CITY OF ALBUQUERQUE

Re: Central Appliance Storage Addition, 4806 Central Avenue SW,
Traffic Circulation Layout
Engineer's Stamp dated 09-01-11 (K12-D031)

The TCL submittal received 05-30-12 is approved for Building Permit. The plan is stamped and signed as approved. A copy of this plan will be needed for each of the building permit plans. Please keep the original to be used for certification of the site for final C.O. for Transportation. Public infrastructure or work done within City Right-of-Way shown on these plans is for information only and is not part of approval. A separate DRC and/or other appropriate permits are required to construct these items.

Traffic Circulation Plan

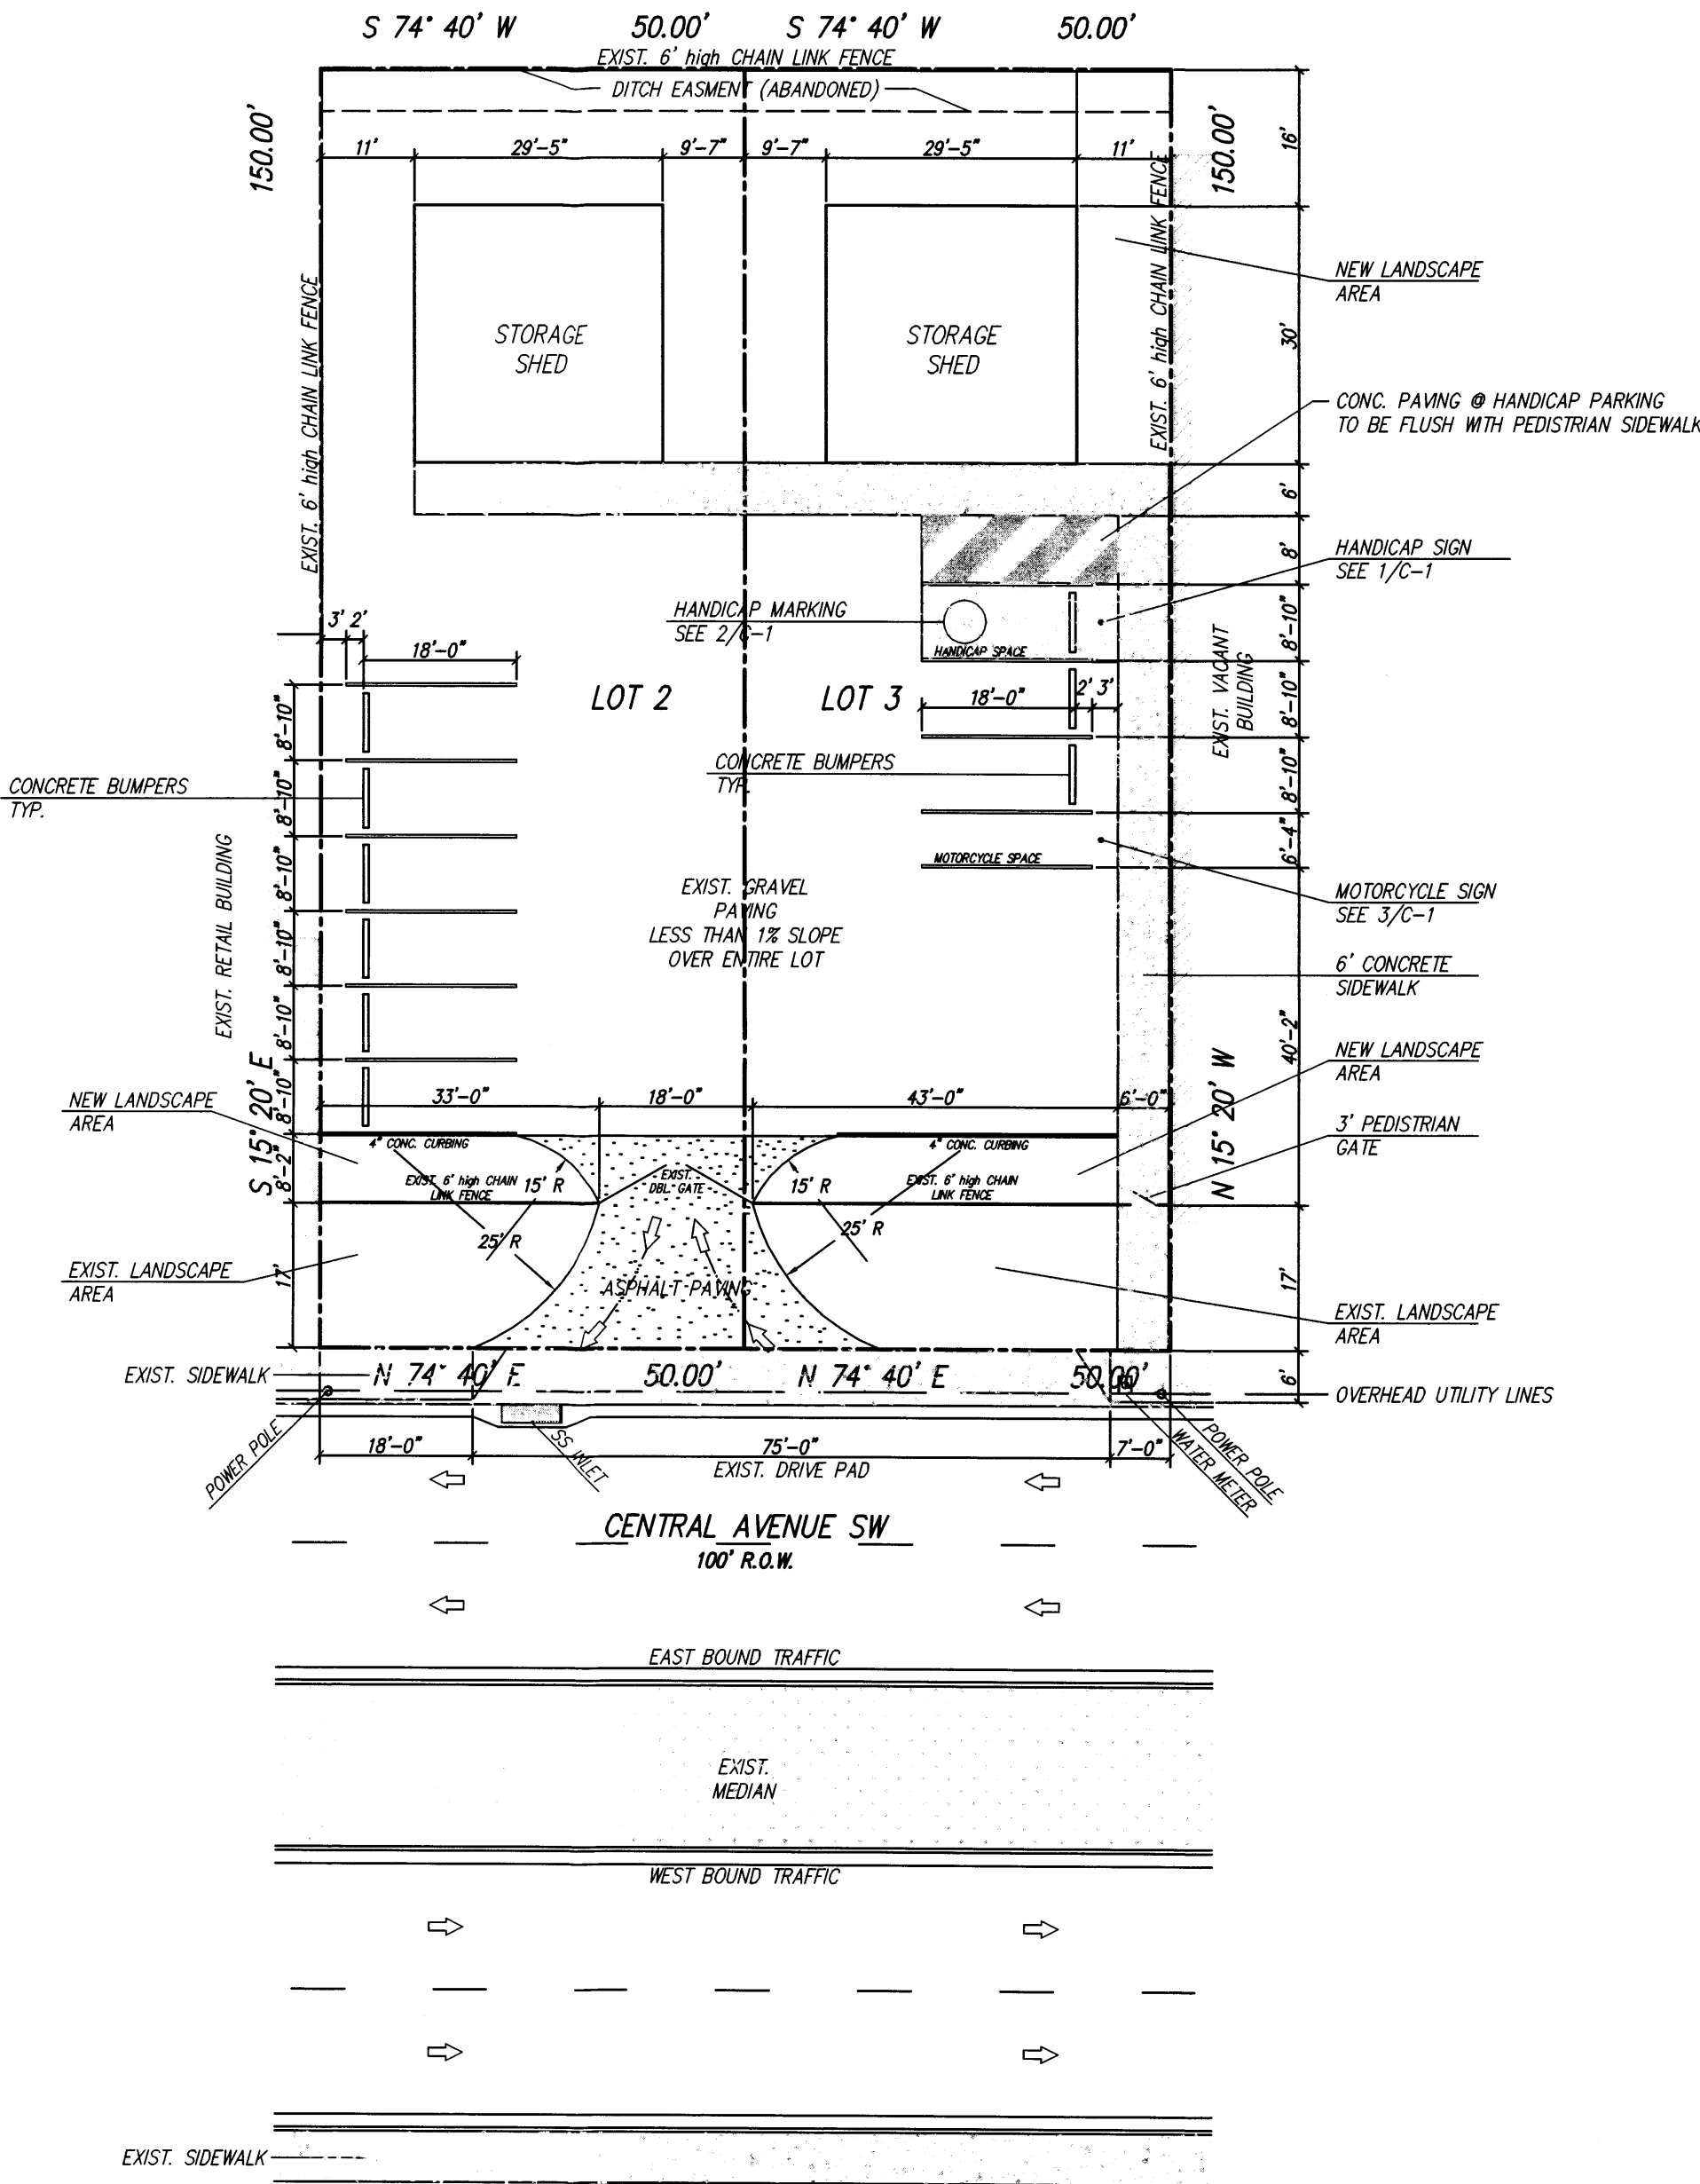
Prior to any certificate of occupancy approval, the following item must be completed:

- **A recorded copy of the cross access easement between lots 2 and 3 must be provided.**
